State of Washington
DEPARTMENT OF FISH AND WILDLIFE

December 1, 2017

RE: WDFW comments on LP-17-00007 Swauk Valley Ranch Long Plat Application

Sheet 2 of 3

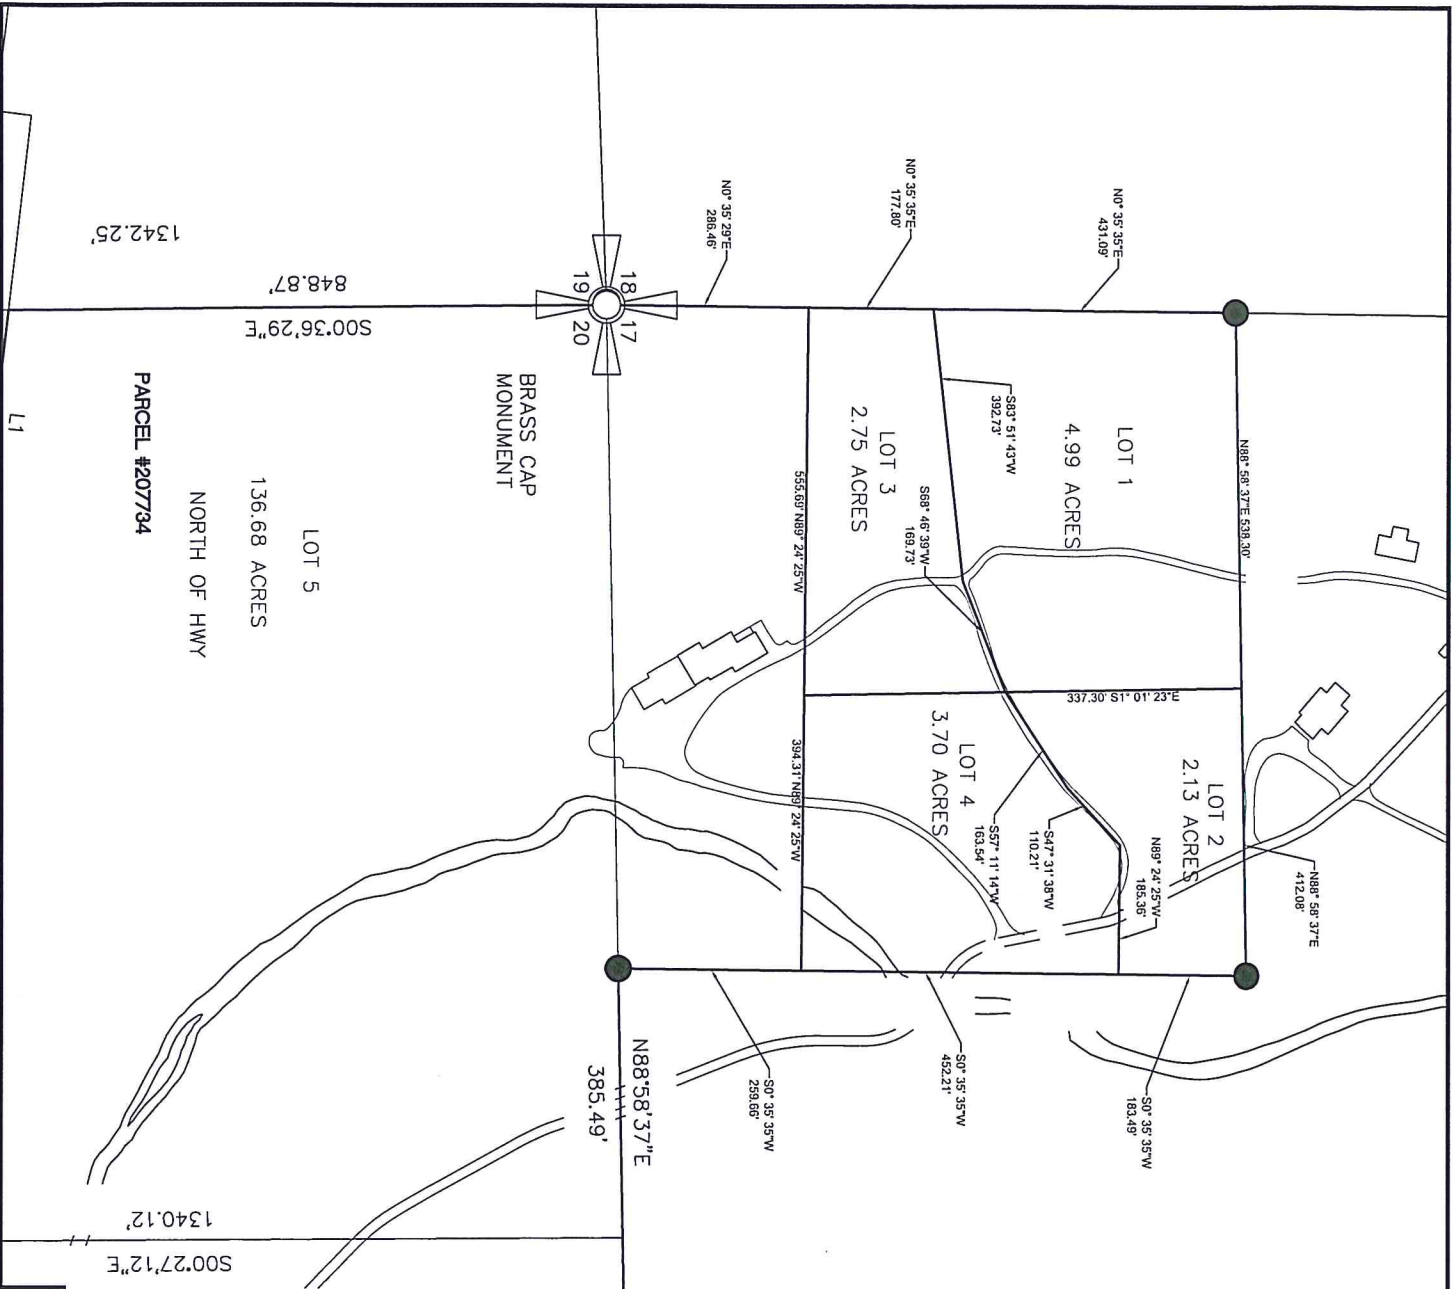
The maps attached with this land use action do not seem to reflect the recent boundary line adjustment (BL-16-00012), making it difficult to determine where the new parcels will actually be as they seem to be north of the mapping shown. We have done our best to determine approximate new lot lines as they will pertain to fish and wildlife resources, but request updated mapping showing the proposed lot lines and their relation to critical areas, shorelines, channel migration zones, and priority habitats for a better analysis.

An unnamed tributary stream flows from the west toward Swauk Creek through the northern portions of the new lots; particularly lot 2. Both lots 2 and 4 may have portions within the Shoreline buffer of Swauk Creek and its channel migration zone. Please clearly show where the buildable areas will be within the new lots (including septic) prior to approval. Buildable areas should take into consideration the current critical area and shoreline buffers and setbacks, knowing that buffer widths may change in the future, and the buildable areas could change as

We strongly urge a revised site plan that shows the buffer and setbacks areas associated with all of the critical areas and Shoreline of Swauk Creek in order to evaluate future buildable areas prior to approval of this short plat. We'd also like to see a wetland delineation and critical areas report to ensure there are no other critical areas within the proposed short plat that would be impacted by future development, including the installation of septic systems and potential impacts on water quality.
